Planning Application Reference No.: 3/2023/1011

Address of Development: 41-43 Wellgate
Clitheroe
BB7 2DP

Comments: Application 3/2023/1011
Flat above 41-43 Wellgate Clitheroe BB7 1LU

Title: Existing and Proposed Site Plans	Drawn: HA
Client: Wajid Mahmood	Checked:
Date: 30-11-2023	Paper: A3
Drawing No: HAD3858-09	Scale: 1:200
Revision:

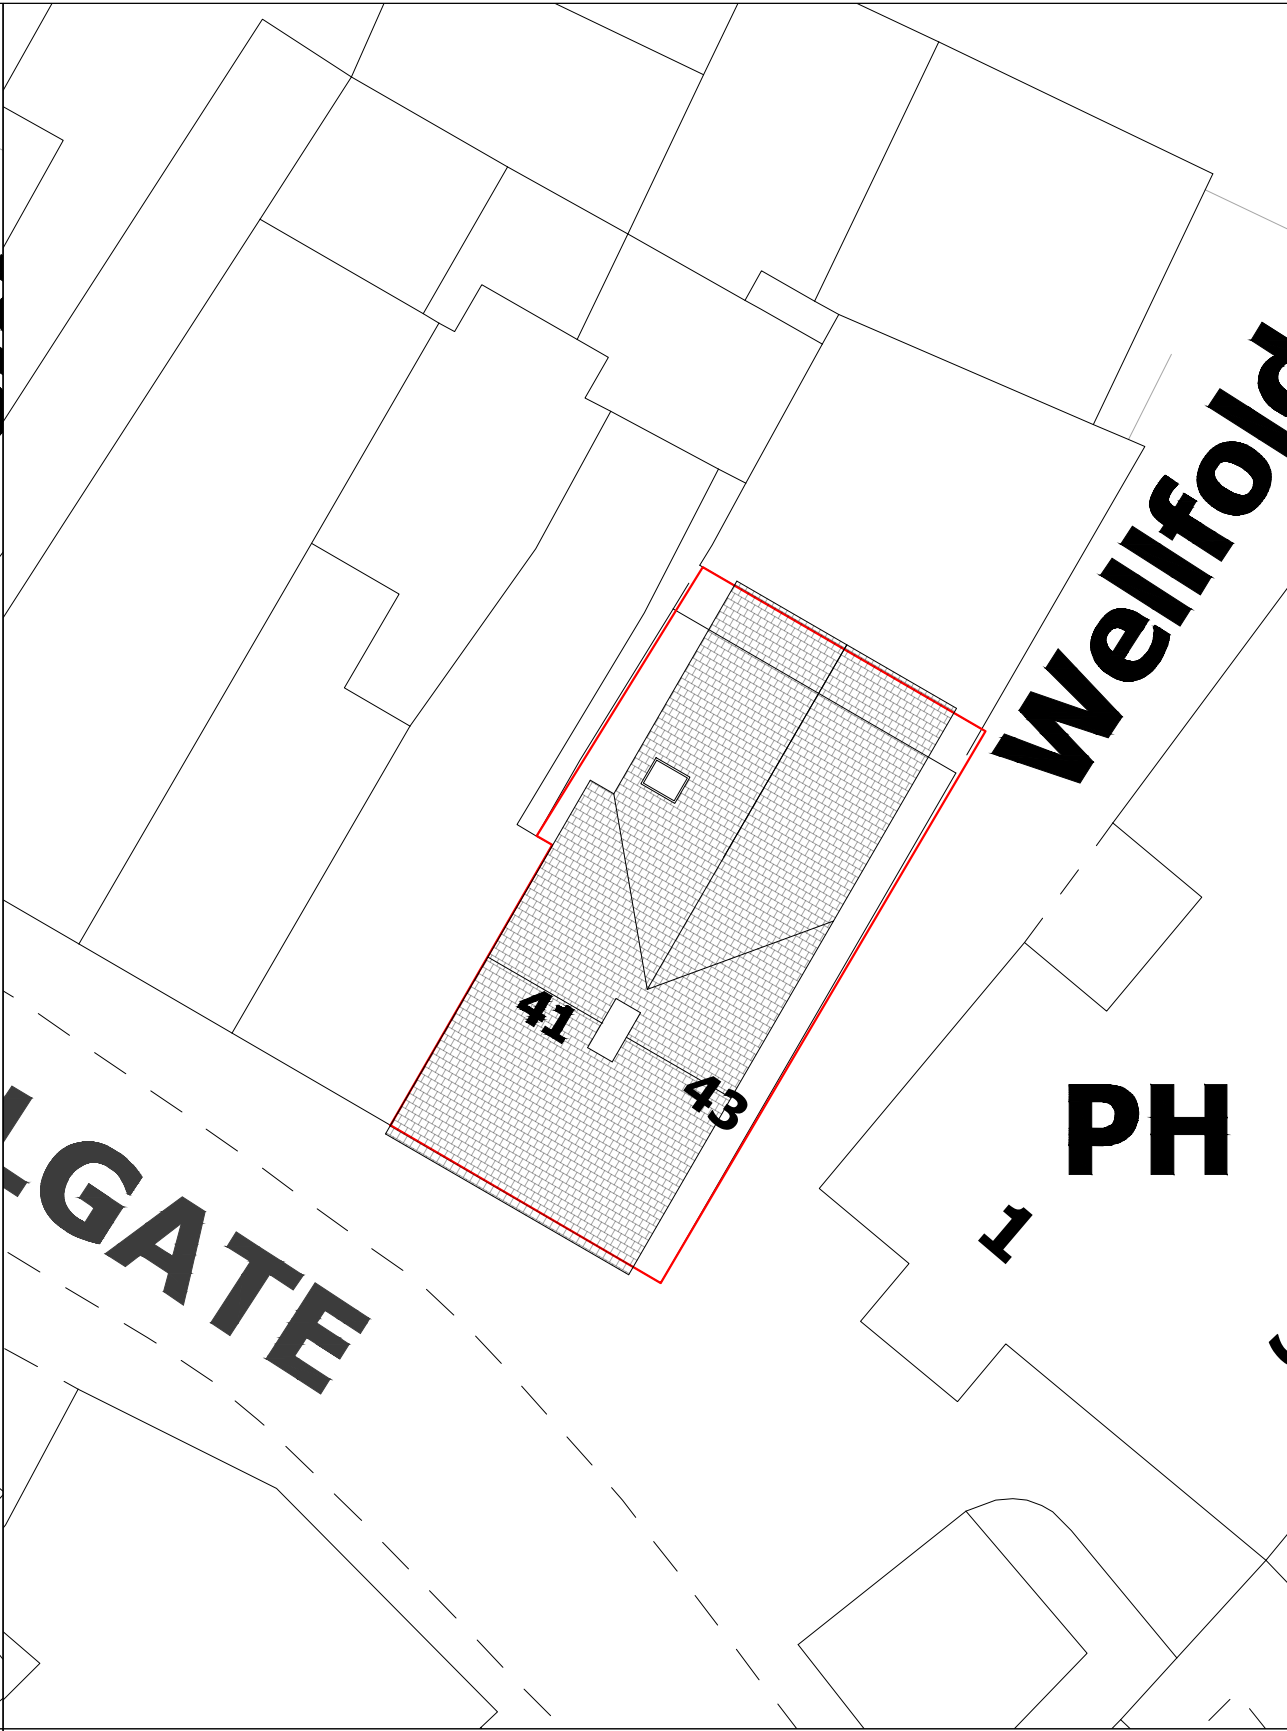
Each commercial and residential site in the area was granted permission to include bin store / area. The bin store mentioned on the application is already shared between [REDACTED] [REDACTED] Even without [REDACTED] property using their own and none of the proposed flats yet existing, [REDACTED] claim not to be able to [REDACTED] [REDACTED] despite being asked not to. Realistically, the siting of 12-18 additional bins and commercial waste skips is simply not possible and they will be abandoned on Wellgate and Wellfold with the associated litter, obstruction and danger to the safety of pedestrians and health of the community with the litter and vermin that already enjoy free reign around the [REDACTED] on its own blocks the pedestrian refuge thus creating further danger to pedestrians who choose to use this route to and from Tesco. RVBC continue to ignore this matter. Photos available of litter and rats.

Even the plan of the applicant shows the bins on collection day being sited in a way that would completely block access to Wellfold, a private driveway, albeit used by pedestrians. This is not acceptable and will not be tolerated.

PROPOSED SECOND FLOOR PLAN - 112m²
1:100 @ A3

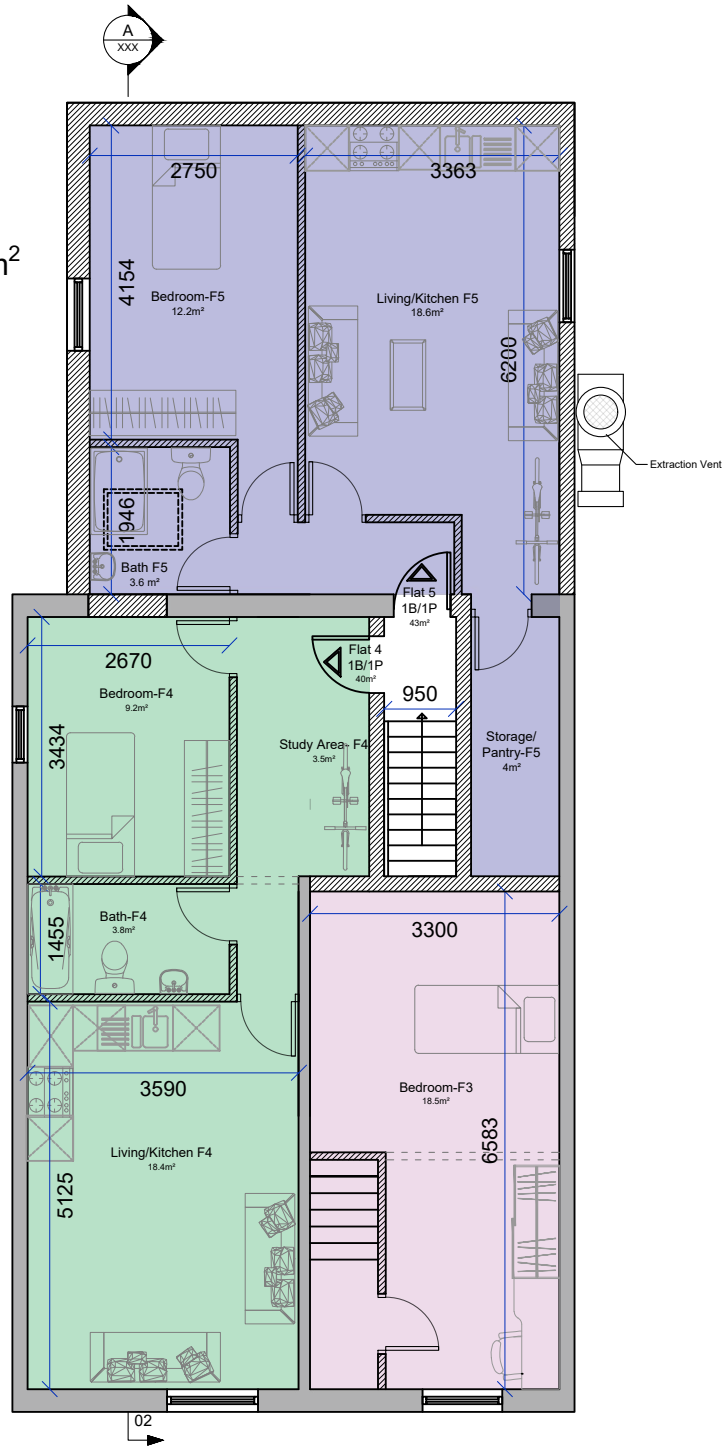
The property 41-43 Wellgate is some significant size in relation to other buildings, the outside space and parking and infrastructure resources available to it. Whilst progress is sometimes required, being sited within a conservation area, the local residents should be able to rely on RVBC not to allow the totally unnecessary destruction of a historical building on a historical road for no other good reason than to make a single property into 6 of them. The quality of the development should also be reviewed to ensure suitability for the area.

Aside from the impact to Wellfold on one side, the addition of a further floor would directly overlook the majority of the private garden of [REDACTED] that connects [REDACTED] This would impact on the quality of life of [REDACTED] be an invasion of privacy, and restrict light to the property. This is not necessary or acceptable to make 41-43 Wellgate a decent liveable space for any new residents and can only be to maximise profits for a developer who will not reside there, at the expense of neighbours and the new occupants themselves.
